**Consultation Response from KC,
 Highways Development Management**
2020/94070 69-71, Cowlersley Lane, Cowlersley, Huddersfield, HD4 5UE
Use of premises for self-service launderette facility and associated works
**Date Responded:
 05/02/2021**
**Responding Officer: Zack
 Turner**
Responding Ref: K2-10SE/27

This application is at 69-71, Cowlersley Lane, Cowlersley, Huddersfield. The proposal is for the use of premises for a self-service launderette facility and associated works.

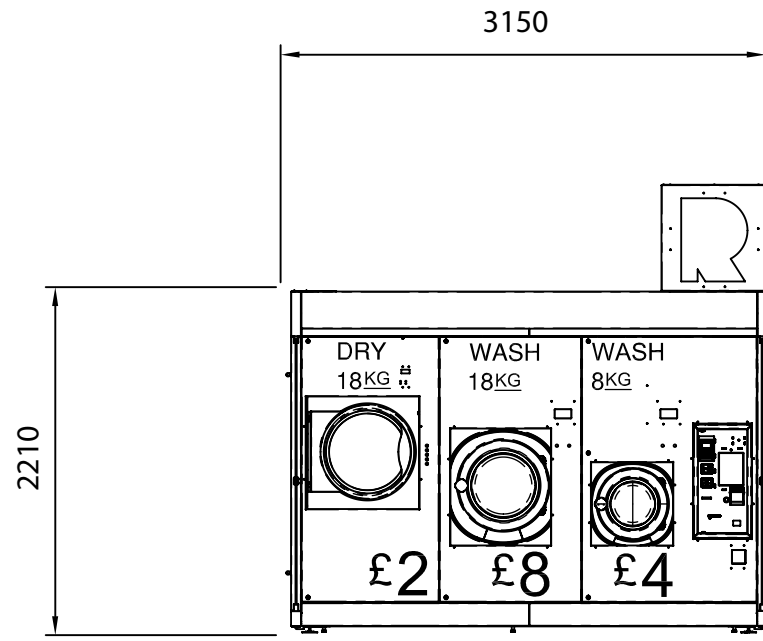
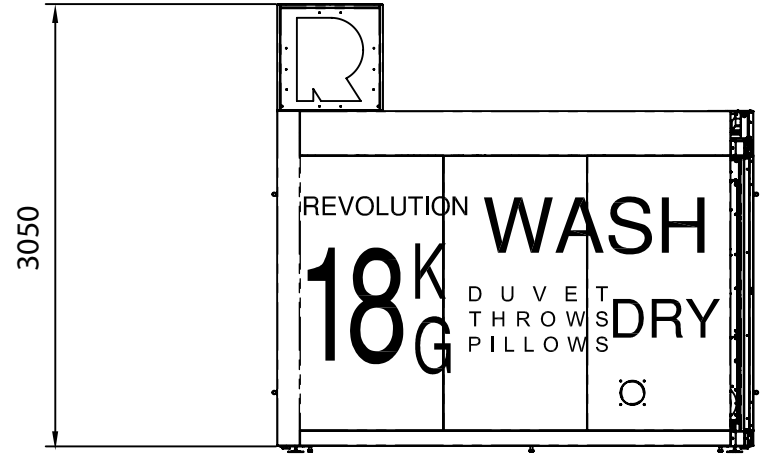
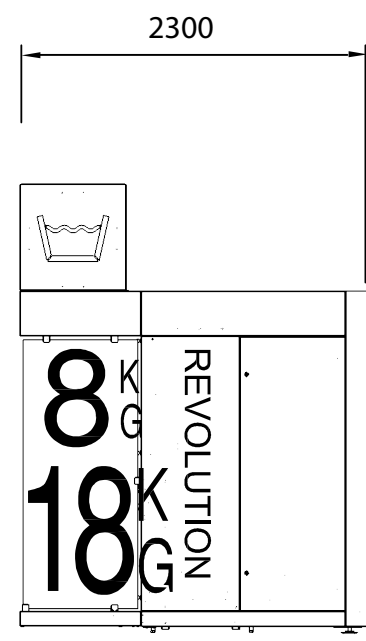
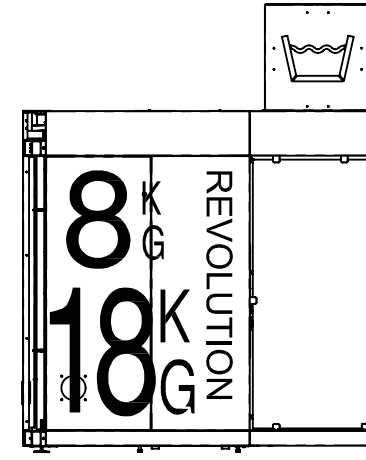
Jubilee Lane is adjacent to the site and serves many dwellings as a rear access which is mainly used for parking arrangements. Visibility splays at the junction of Jubilee Lane onto Cowlersley Lane should be 2.4m x 43m as it is a 30mph road and the new self-service laundrette at the proposed location will significantly obscure the visibility at this junction to 2.4m x 18m. This is considered unacceptable from a highway's safety perspective.

If the location of the site could be repositioned closer to the existing building and away from the edge of the adopted highway then we may be able to reassess the impact on the visibility.

Highways Development Management currently consider that there will be a significant loss of visibility at the junction adjacent the site and therefore are unable to support the application on highways safety grounds with this proposed layout.
